**From:** Gregg, Robert <Robert.Gregg@lancashire.gov.uk>  
**Sent:** 01 February 2019 13:01  
**To:** Adam Birkett  
**Cc:** planning; LHS Customer Service  
**Subject:** APP. 3/2019/0049 - DUKE OF YORK INN, GRINDLETON BROW, GRINDLETON

**Change of use from public house with living accommodation to one dwelling with business use. Demolition of existing single-storey extensions and construction of new single-storey extension. Construction of new, two storey three-car garage with business storage above. Construction of three new two-storey holiday lets.**

Drawing Title
 PROPOSED HOLIDAY LETS:
 ELEVATIONS

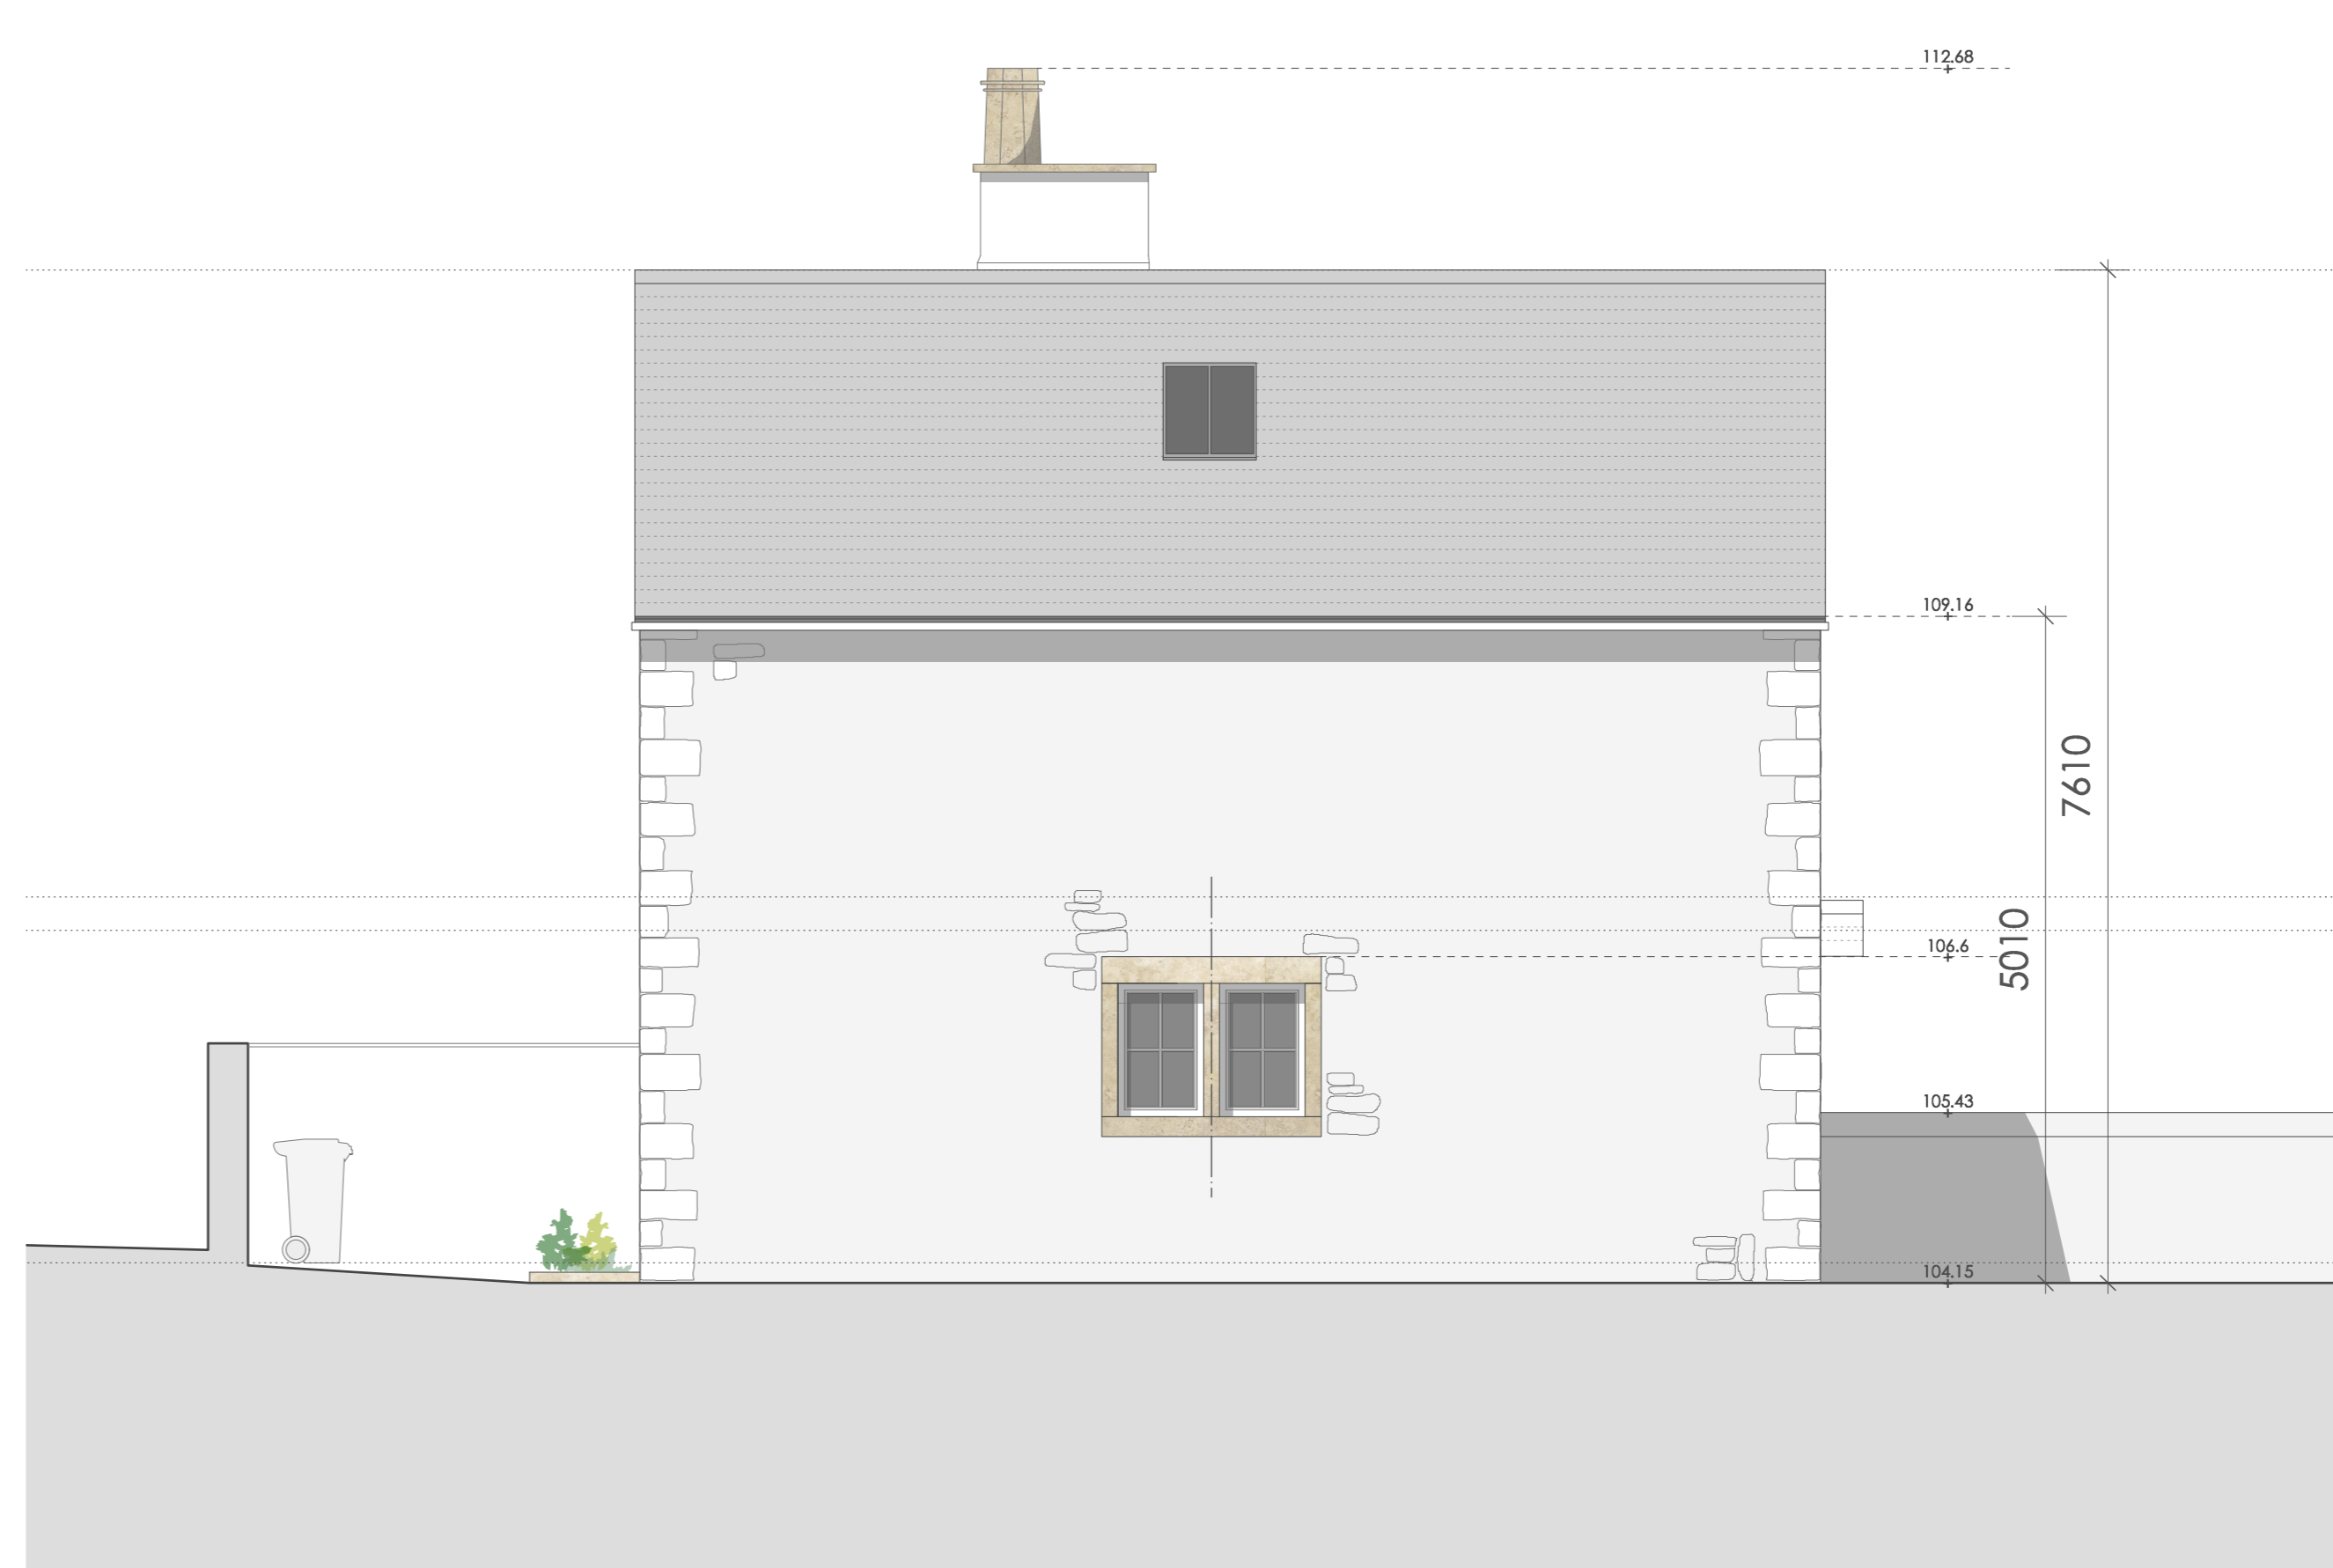
The parking provision for the development is sufficient and the parking arrangements as proposed are acceptable. However, the wall as illustrated to the end of the three parking spaces associated with the holiday lets, along with the boundary wall fronting the holiday lets to the rear of the newly proposed footway shall be no greater than 1.05m in height so that they do not impede on drivers visibility.
